DRB CASE ACTION LOG (FINAL PLAT)

DRB Application No.: 06DRB-00587 (FP)
Project Name UNIVERSITY CROSSING
Agent: Rio Grande Engineering

CITY OF ALBUQUERQUE
Planning Department
February 15, 2006
DRB Comments

RE: University Crossings/major pp

**PRELIMINARY PLAT OF
UNIVERSITY CROSSINGS
WITHIN SECTION 27
T. 10 N., R. 3 E., N.M.P.M.
CITY OF ALBUQUERQUE
BERNALILLO COUNTY, NEW MEXICO
JANUARY 2006**

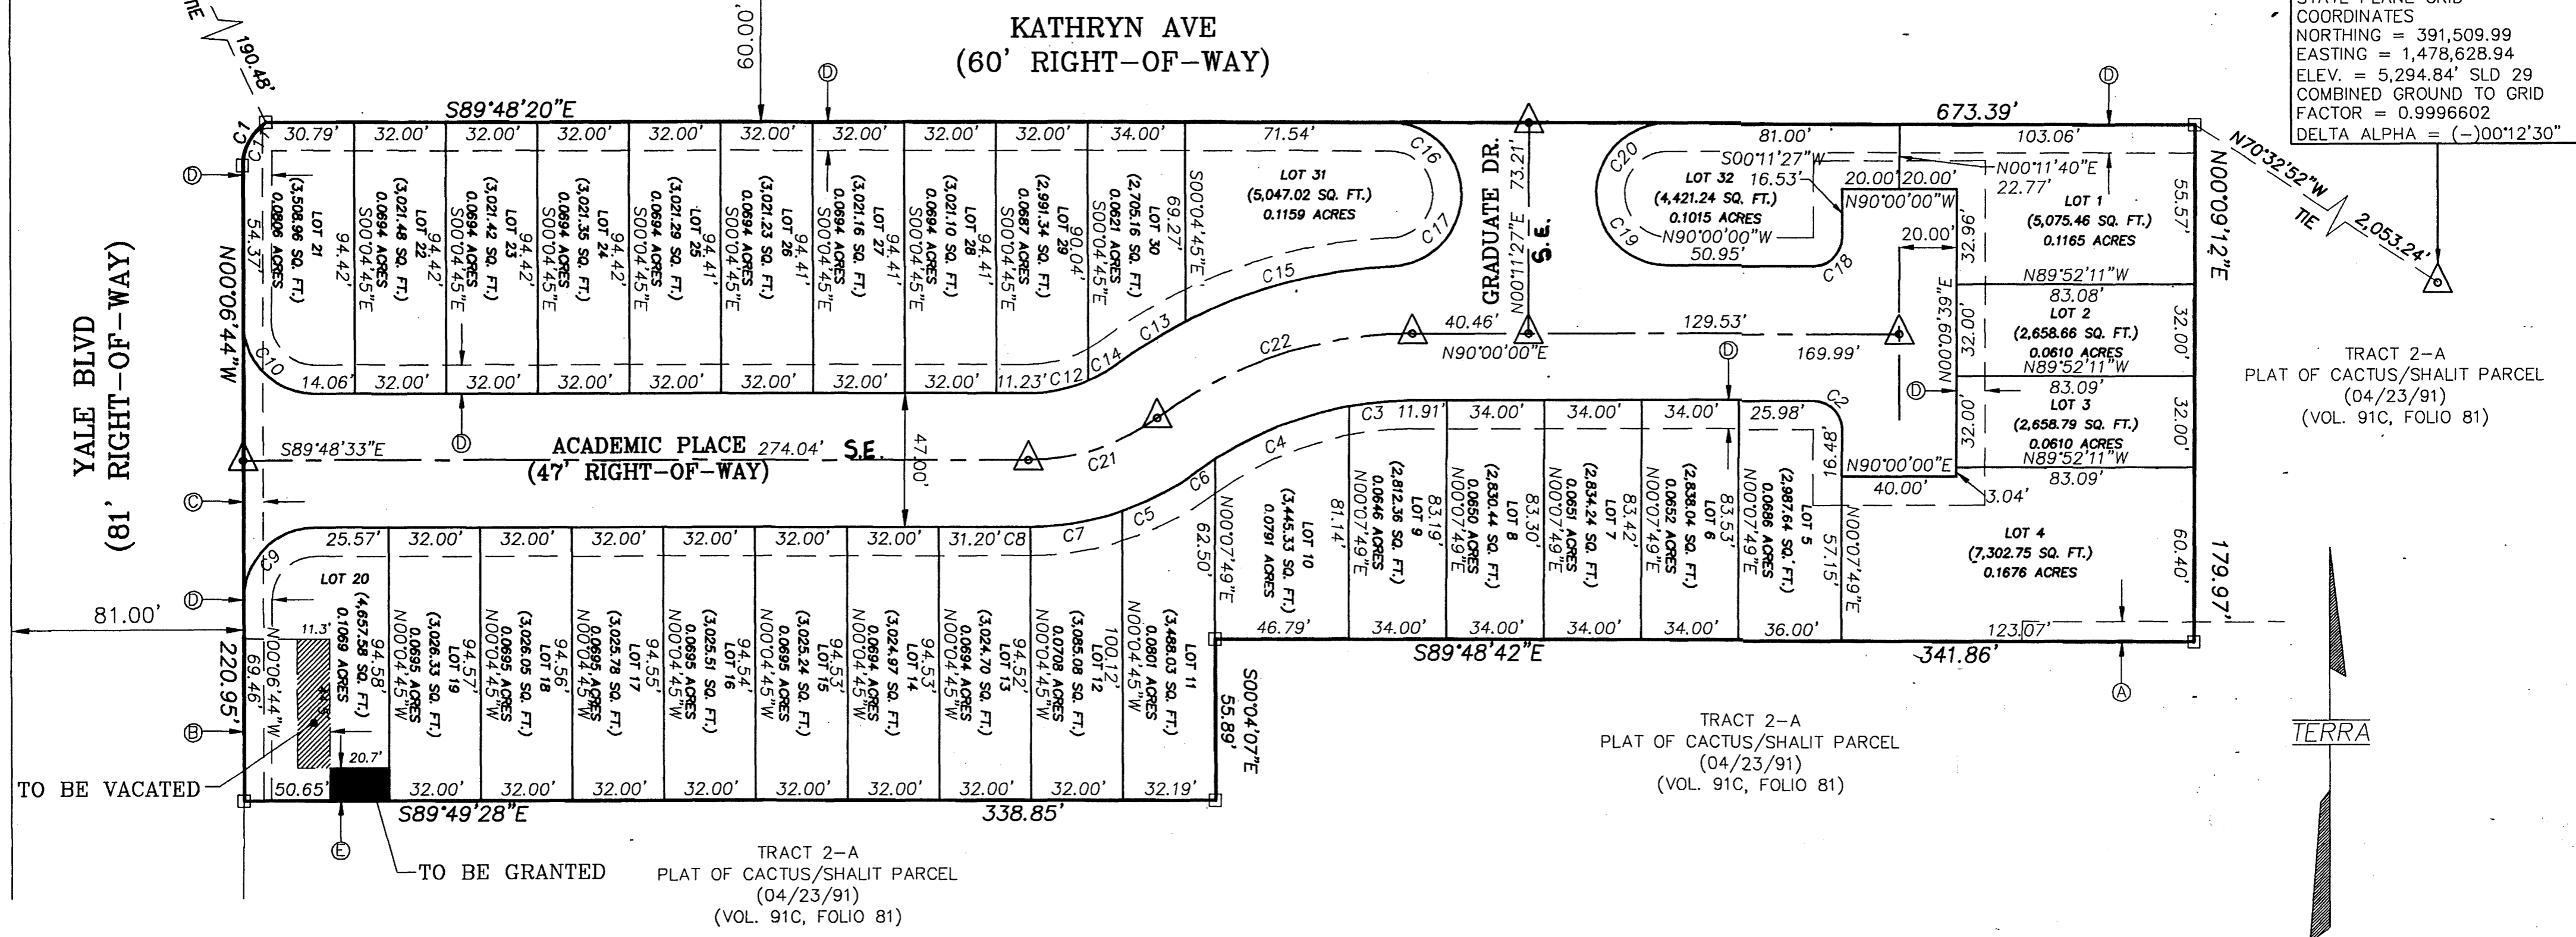
The current zoning needs to be put on the plat.

- 
- ✓ The current zoning shall be placed on the final plat.
 - ✓ Need to evaluate right-of-way dedication along Yale Blvd.
 - ✓ Need a Signal Analysis at Kathryn SE and Yale SE.
